DECISION DELEGATED TO DEVELOPMENT MANAGER

Application No: H13-0026-21 **Applicant:** Mr & Mrs Ford

Proposal: Details of full photographic building recording, doors, windows and rooflights (Conditions 3, 4, 5 and 6 of H13-0865-20)

Location: 7 Broad Lane Moulton Spalding

Flush Casement Window, Typical Vertical Section
Scale 1:10

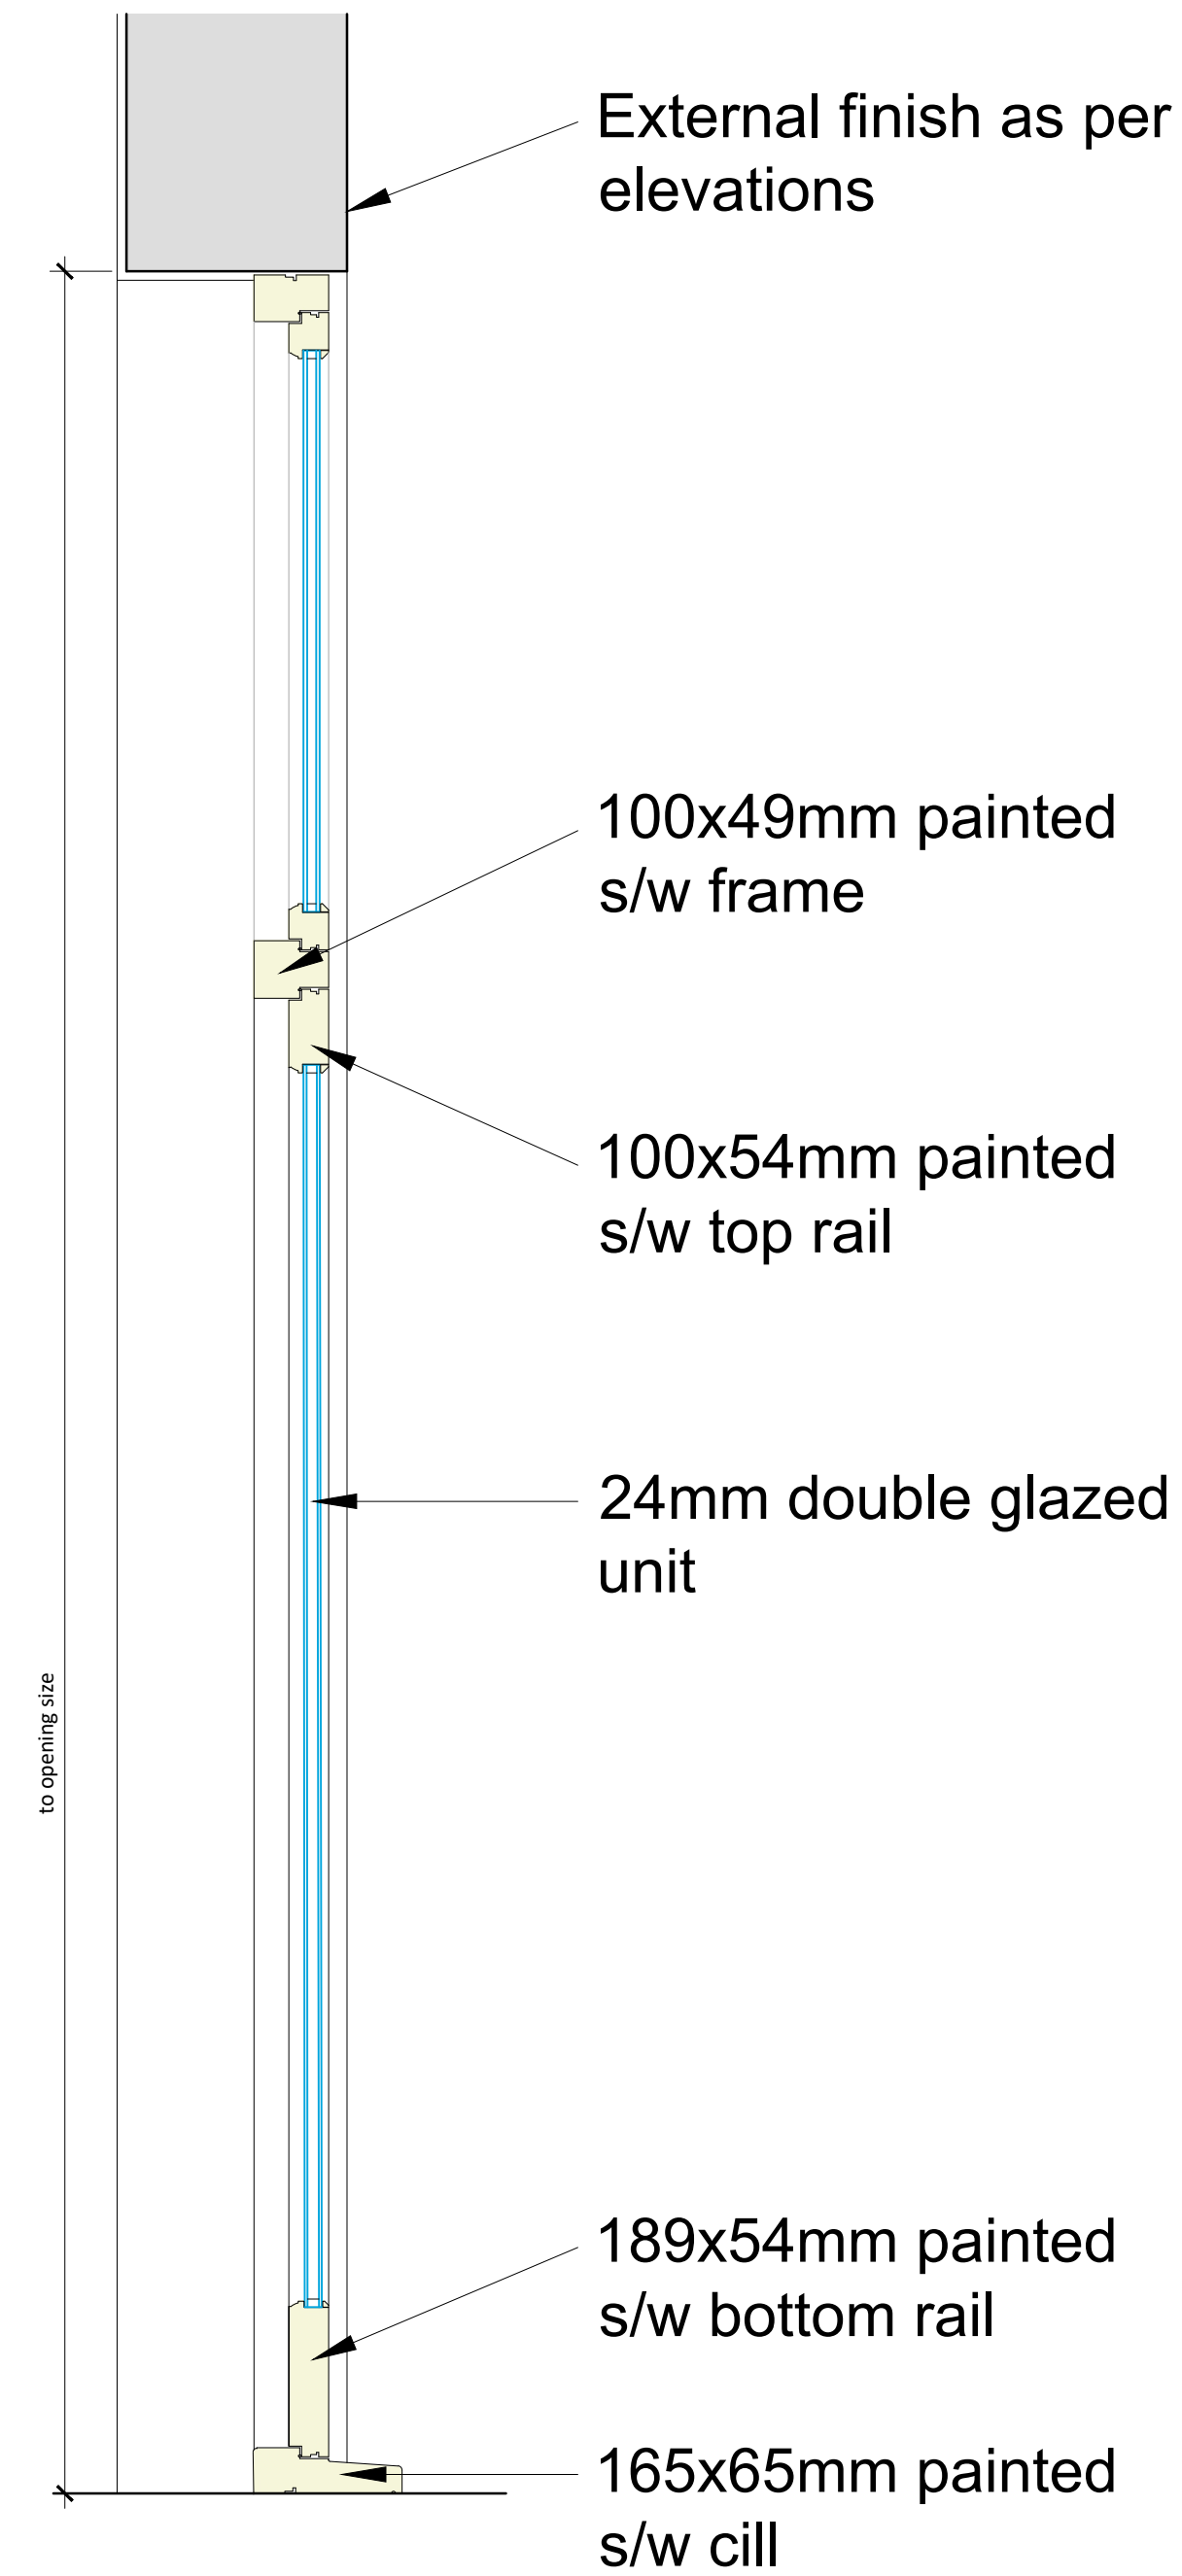
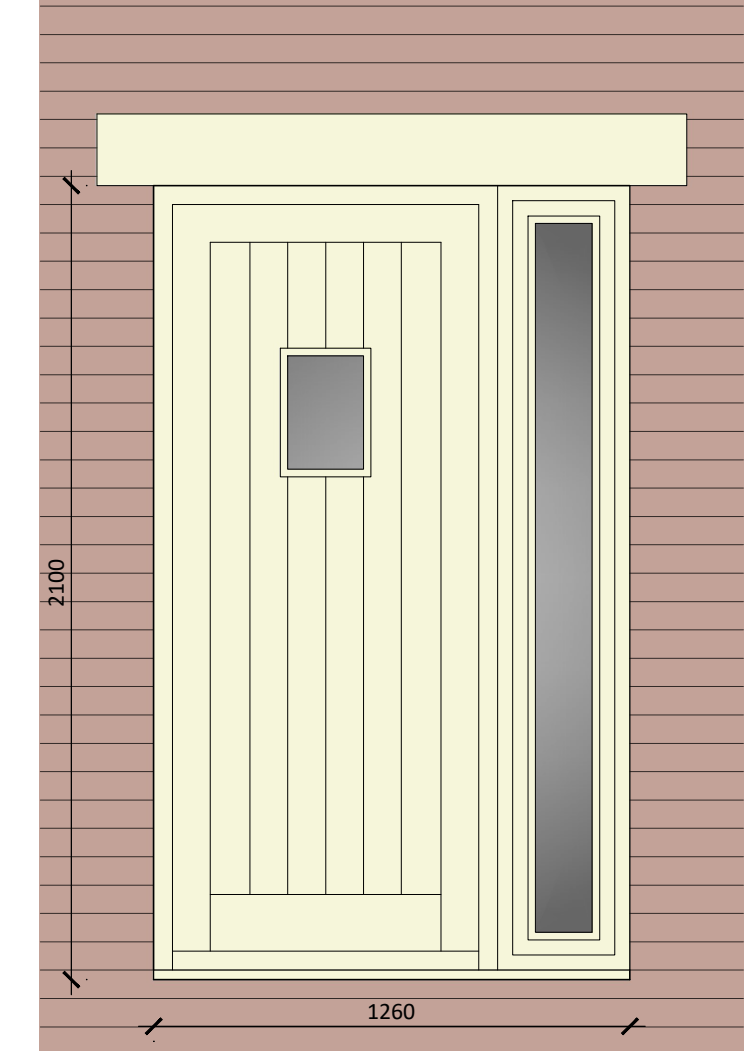
The details of the window frames to be used have been presented and deemed by the local planning authority to be satisfactory due to the timber nature of their construction and the slimline, conservation style assembly of the glazing. Furthermore, their design is deemed to be fully appropriate to the property, being of either mock-Victorian style with glazing bars or disguised as traditional barn-style doors. This condition, therefore, may be discharged.

External Door, Typical Vertical Section
Scale 1:10

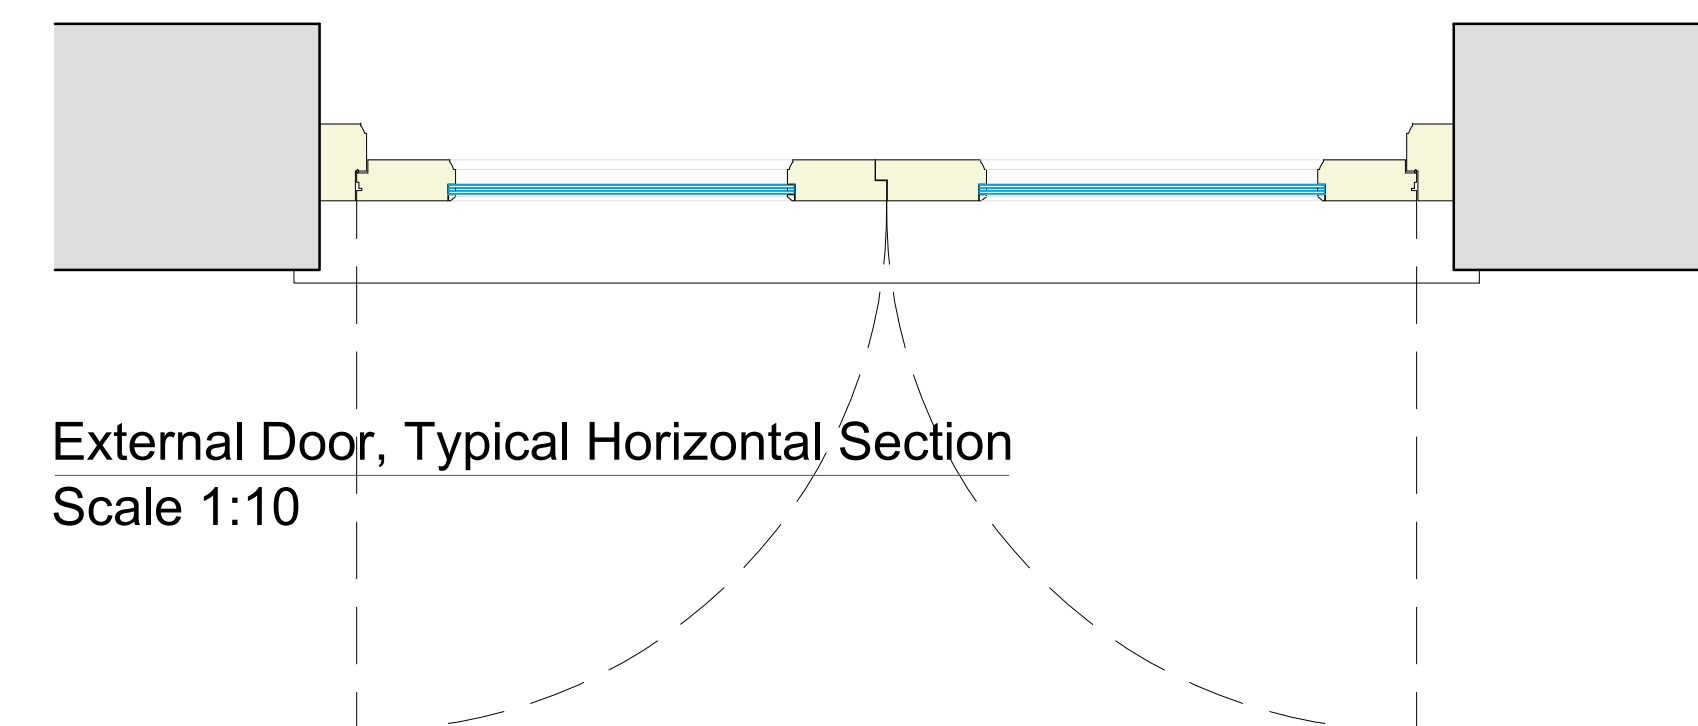
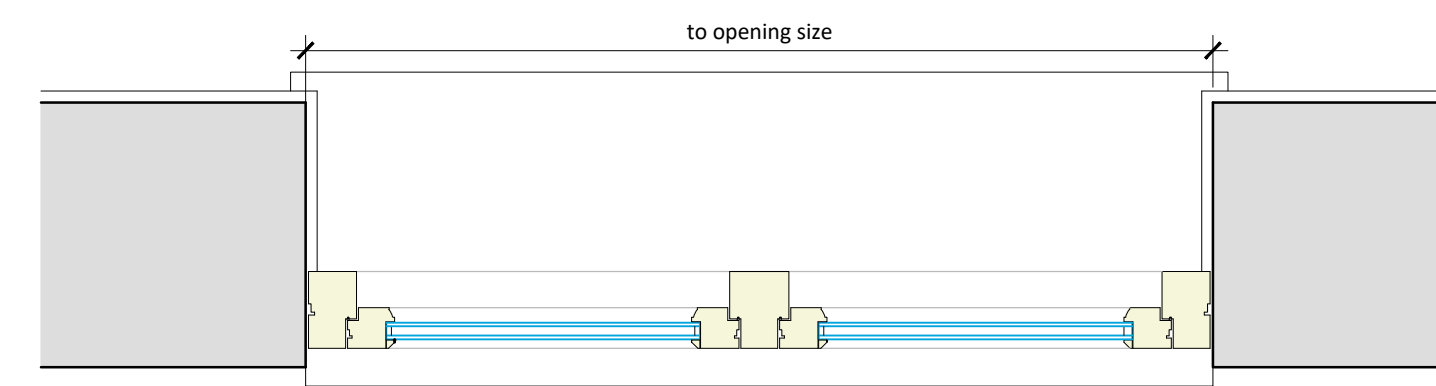
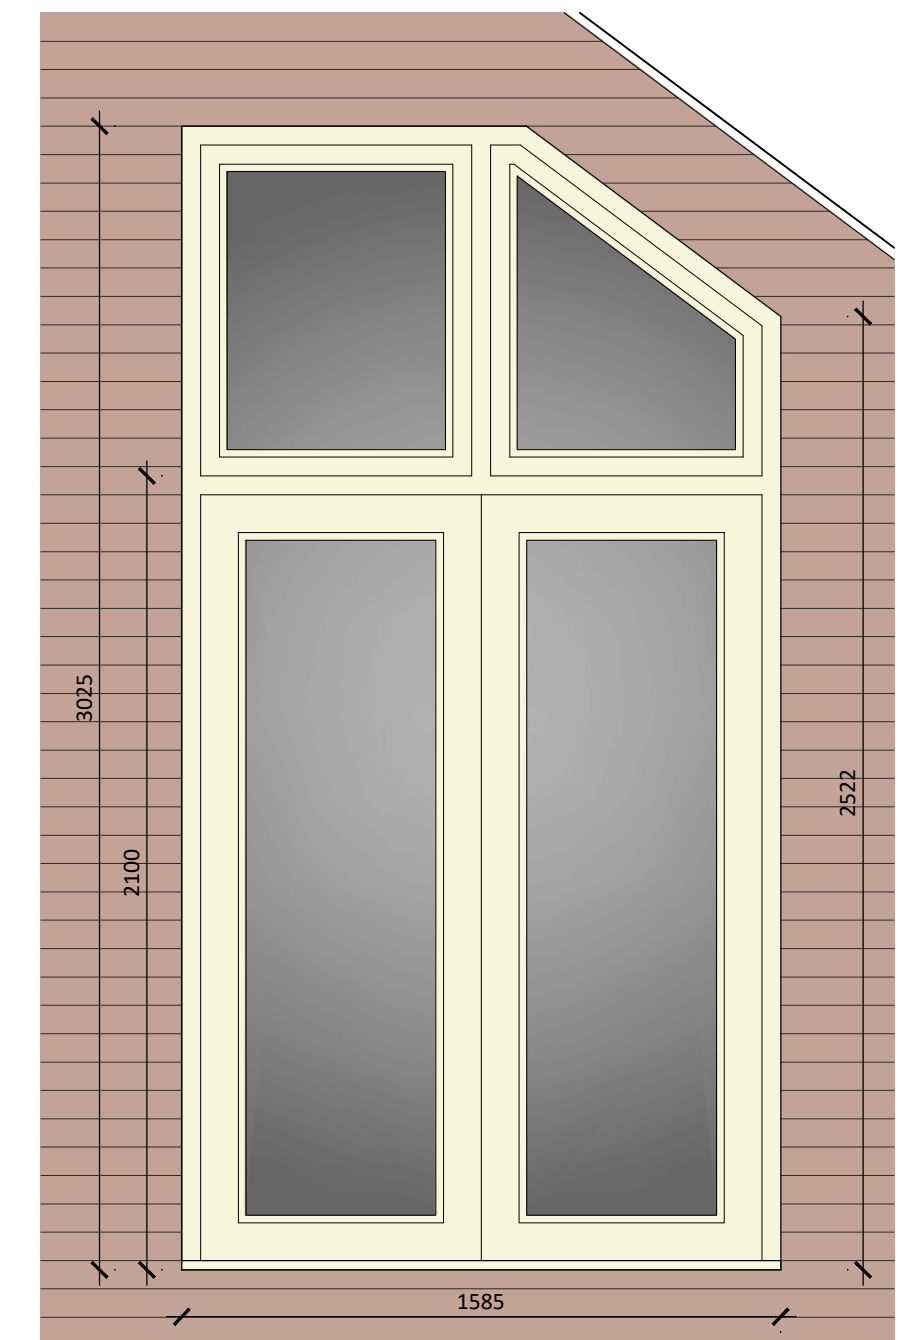
The details of the doors and door frames to be used have been presented and deemed by the local planning authority to be satisfactory due to the timber nature of their construction and the slimline, conservation style assembly of the glazing. This condition, therefore, may be discharged.
